Southampton to London Pipeline – written representation from Ashford Road, TW18

Southampton to London Pipeline Project

Application for a Development Consent Order – Reference EN070005

Ashford Road (TW18) Residents Group Written Representation, November 2019

Drawing title	<div>CROSS COUNTRY VALVE TYPICAL COMPOUND PLAN & SECTIONS REGULATION 5 (2) (O)</div>						
Drawing status	Fit for Stage Approval						
Scale	VARIOUS			DO NOT SCALE			
Jacobs No.	B2325300			Rev	C01		
Client no.

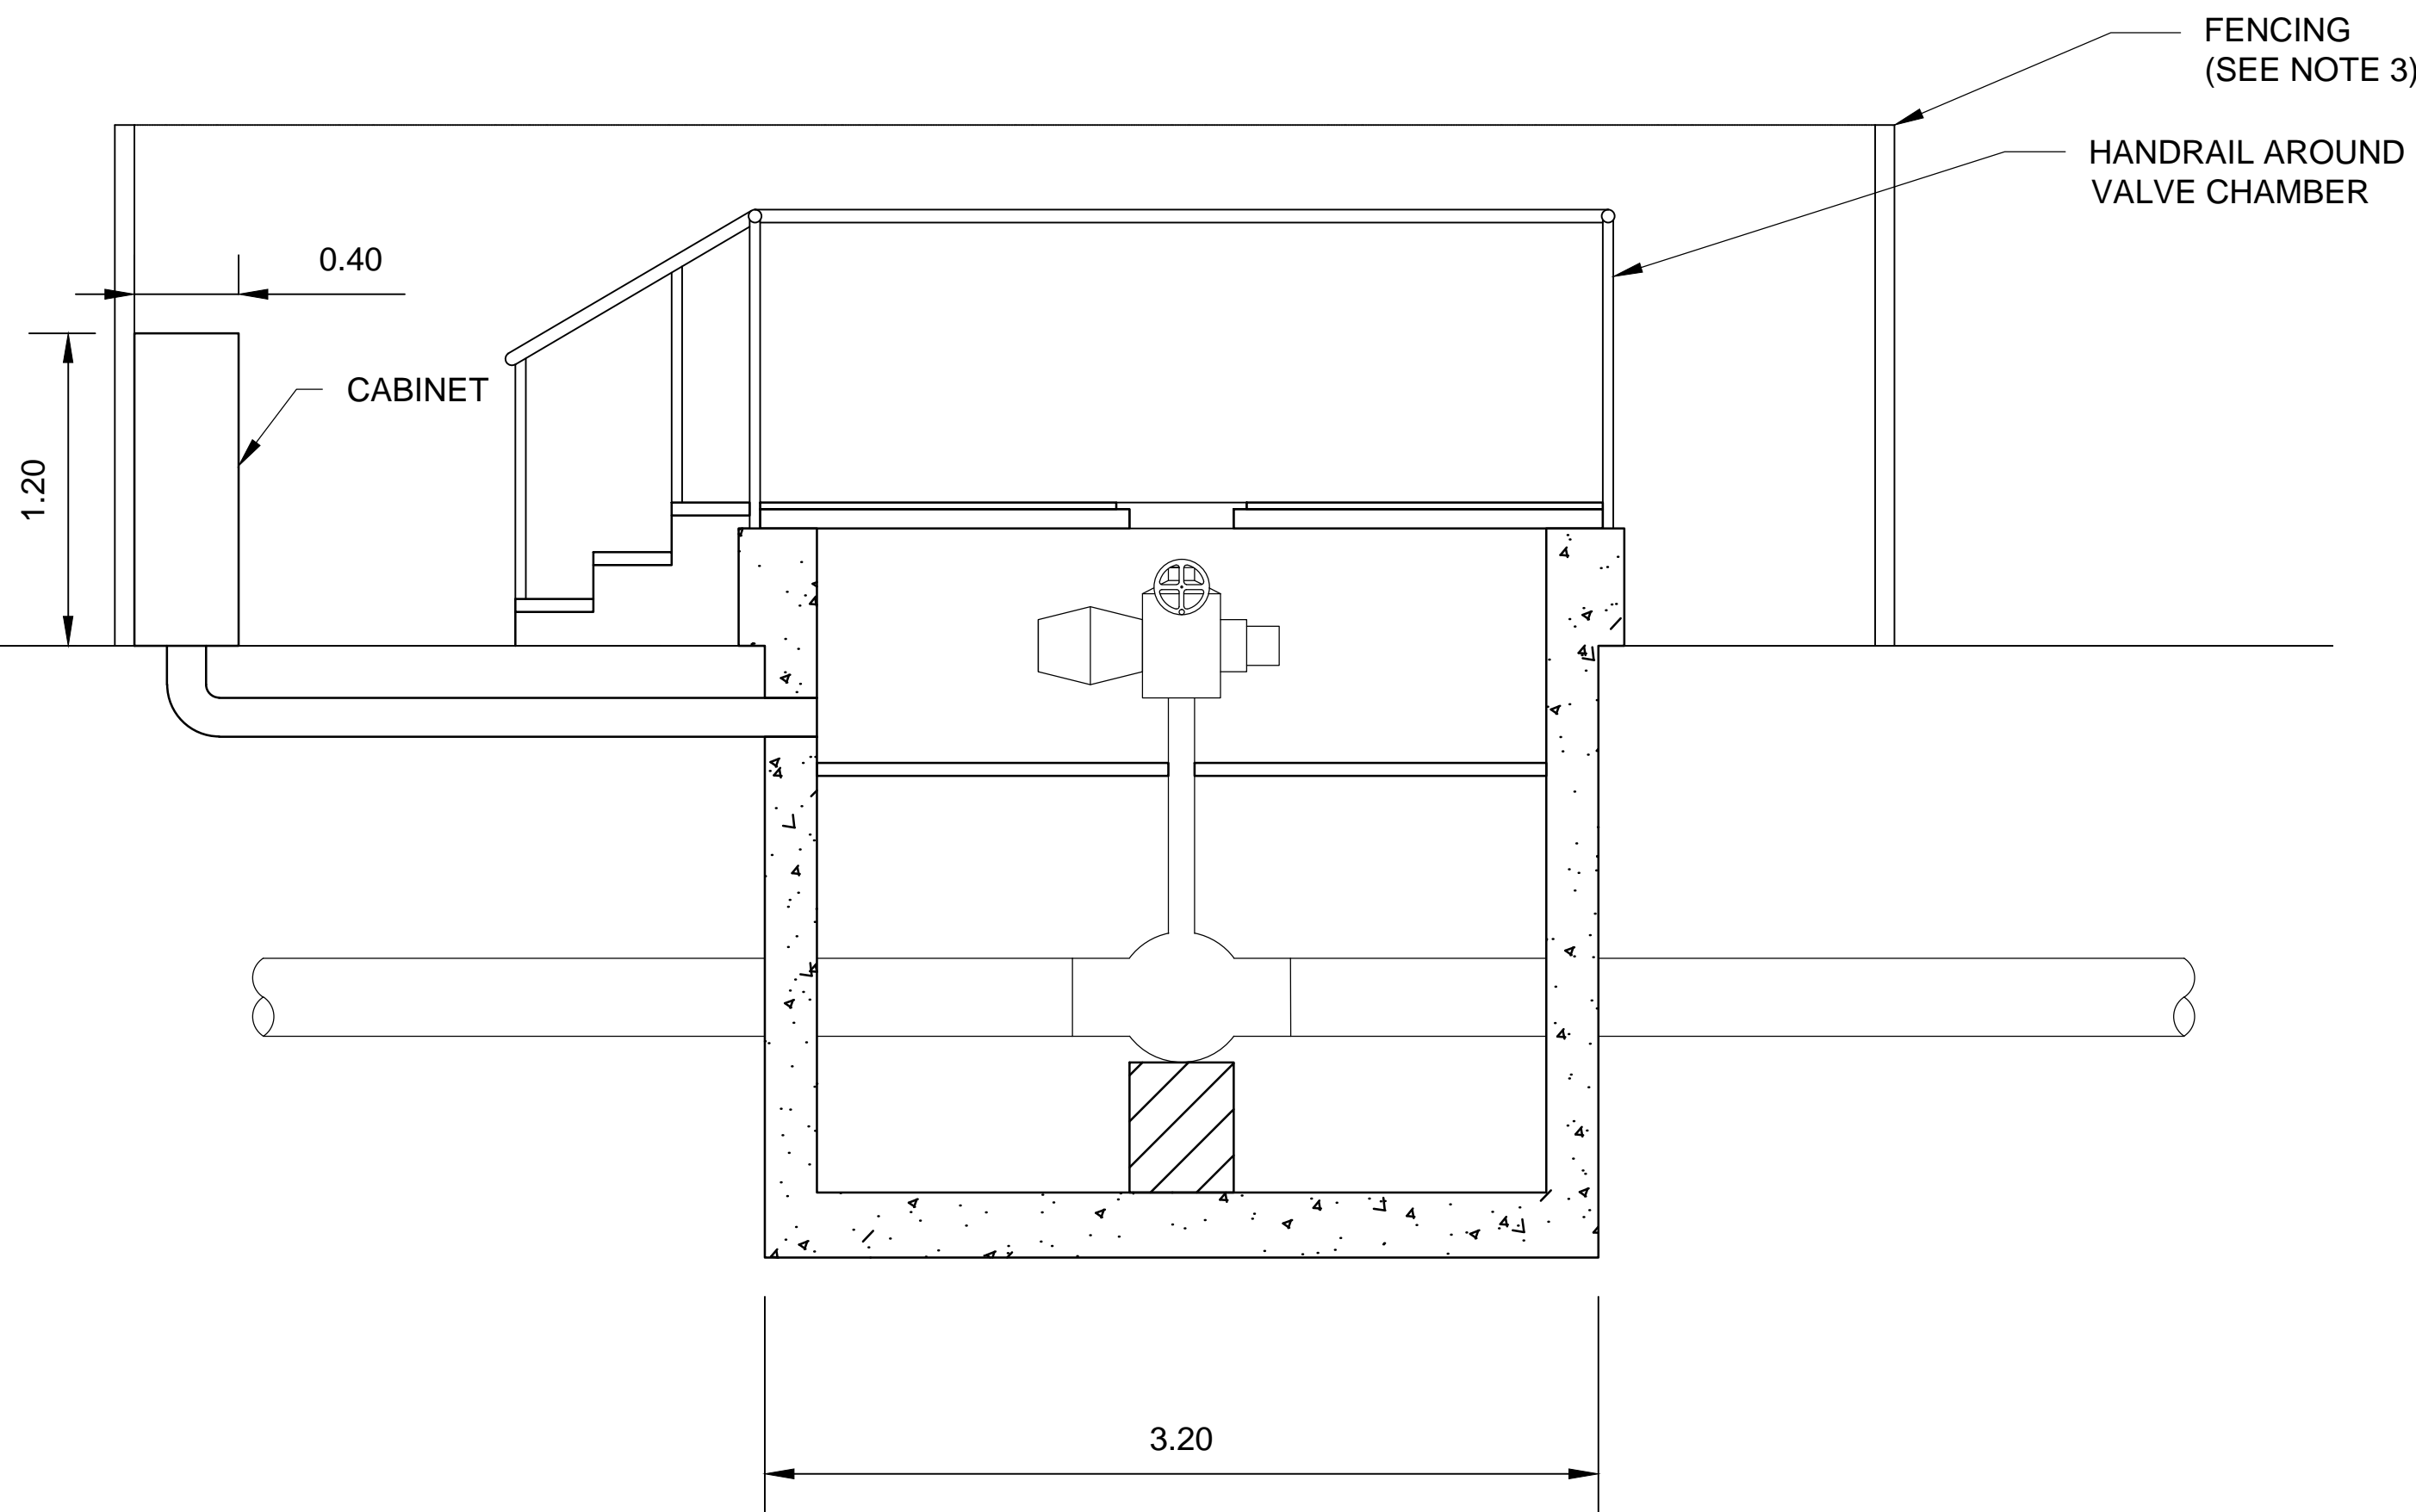
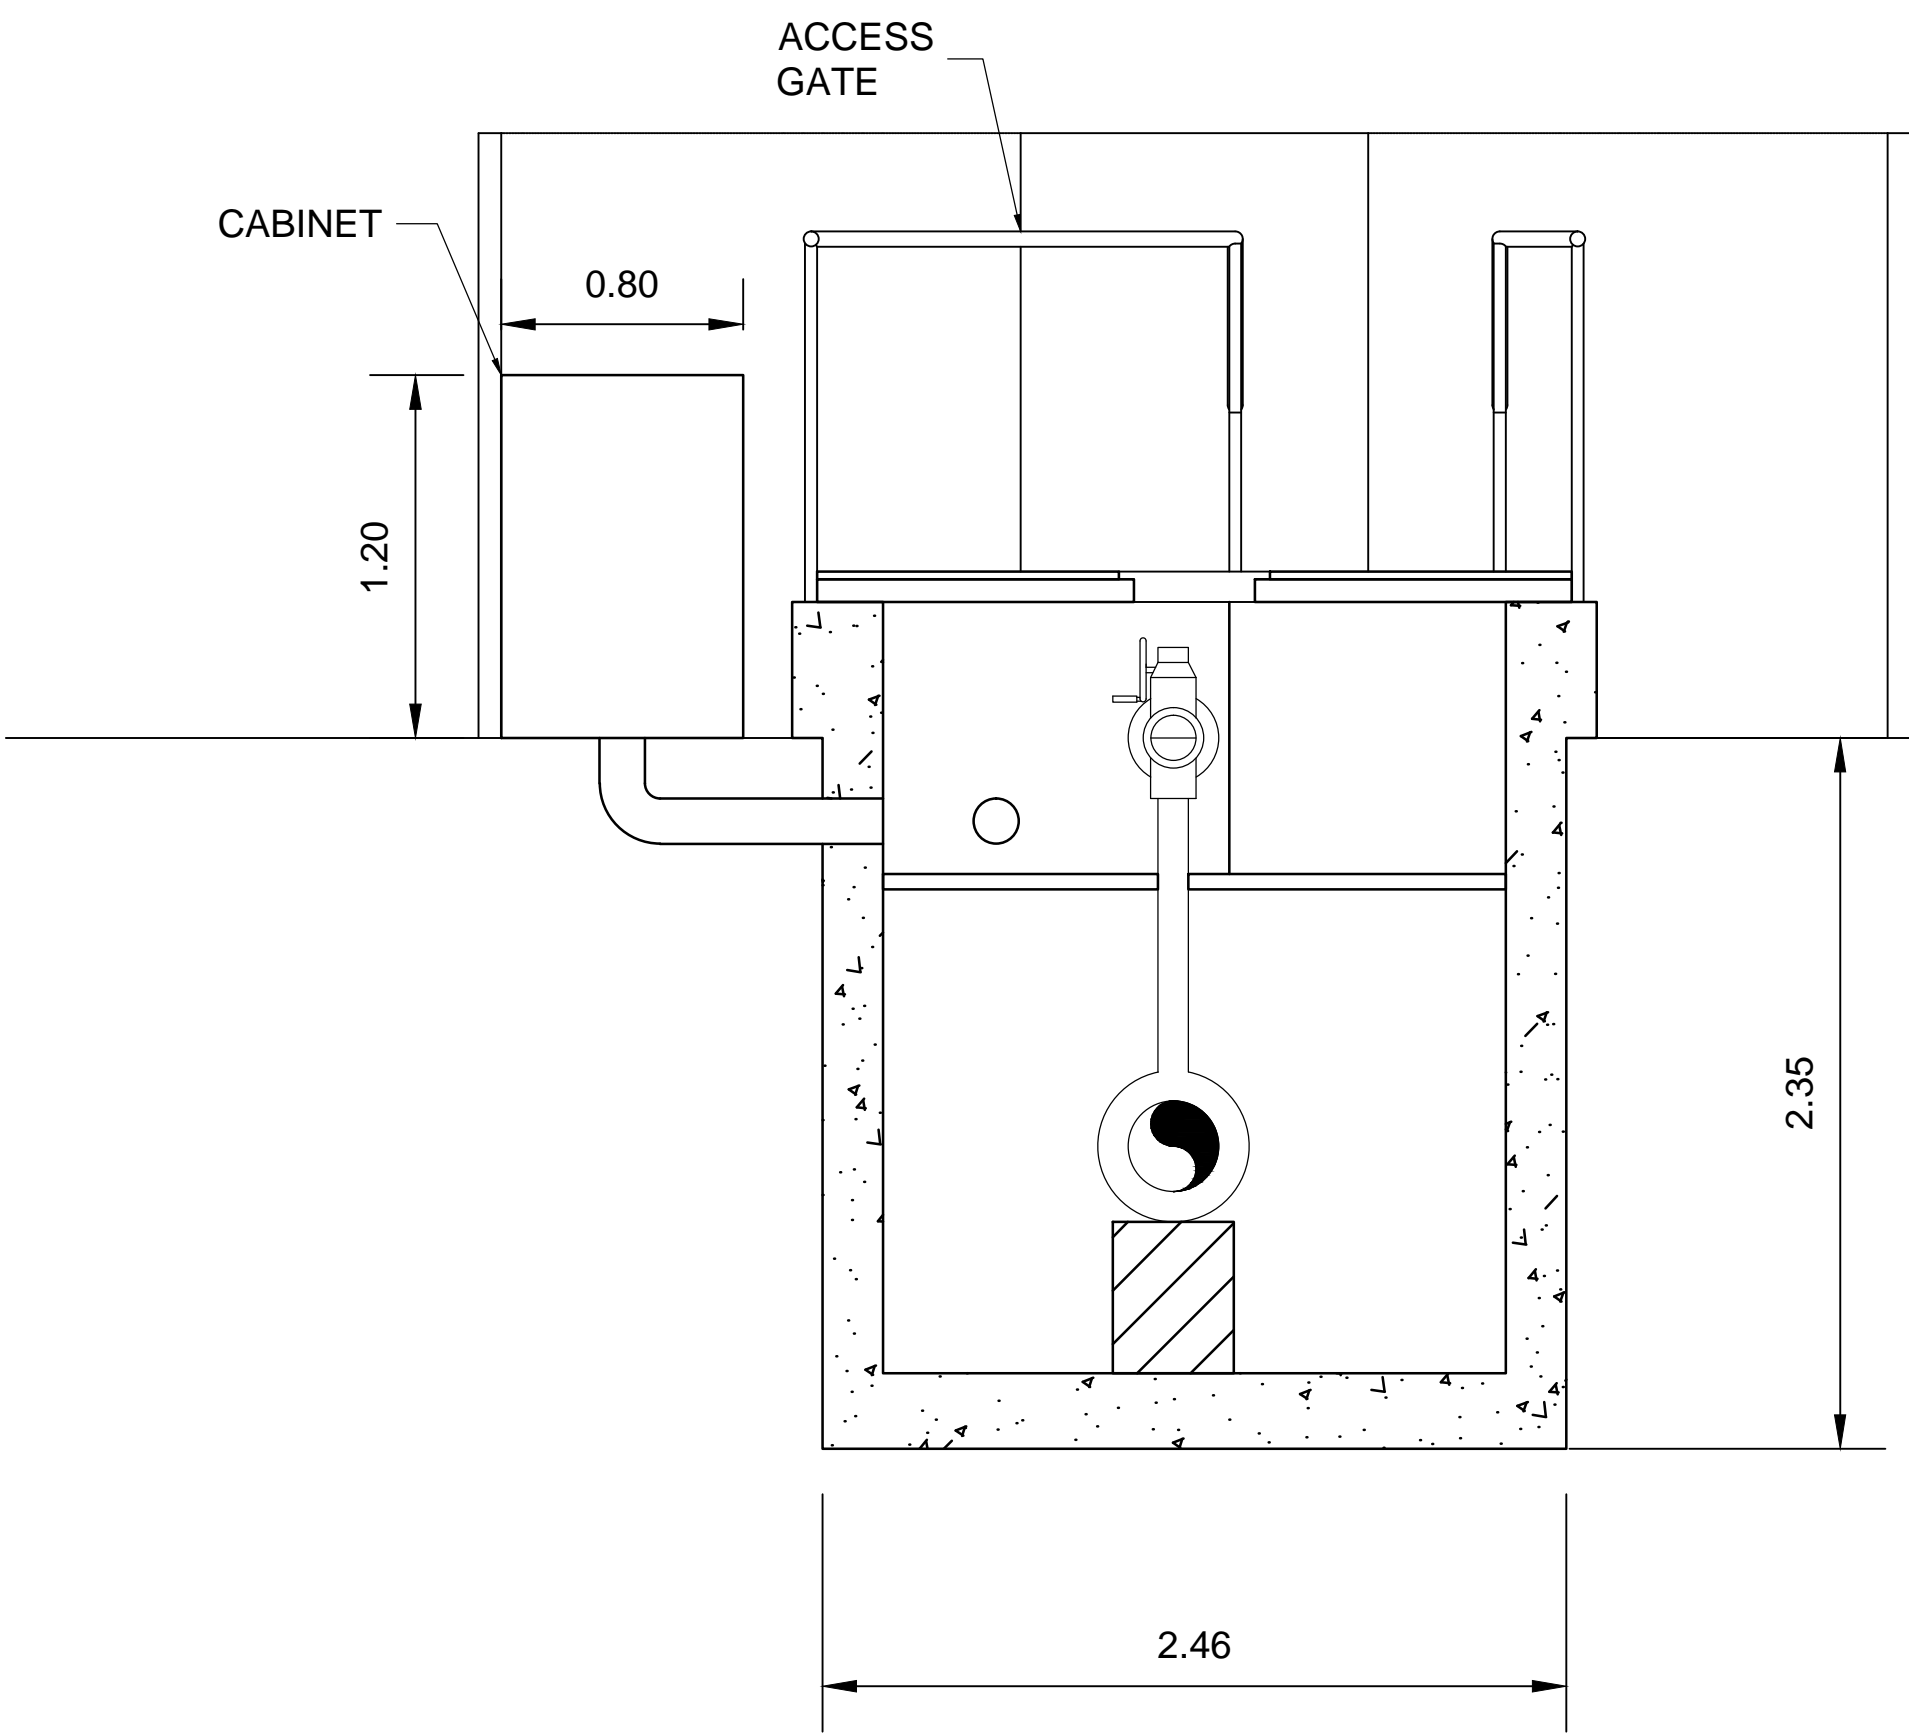
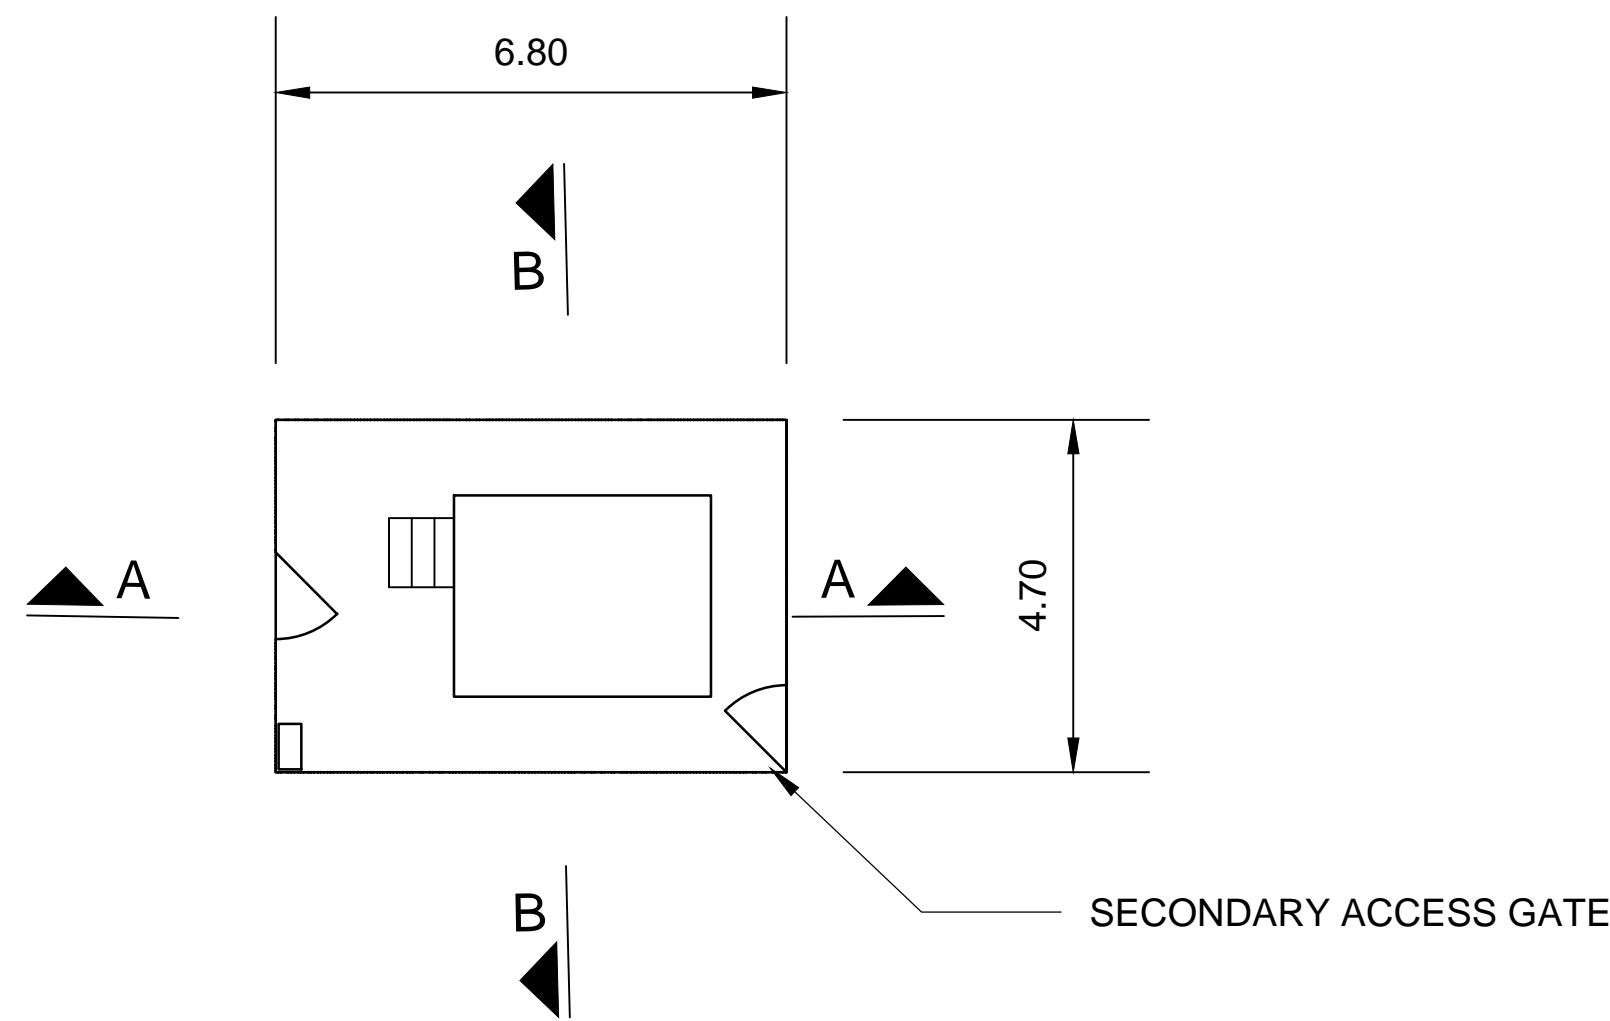
Q26a. The above plan does not detail associated off road parking with Work No 11E or VA 2O. Is this referring to the temporary access at locations 9AN and 9AO?
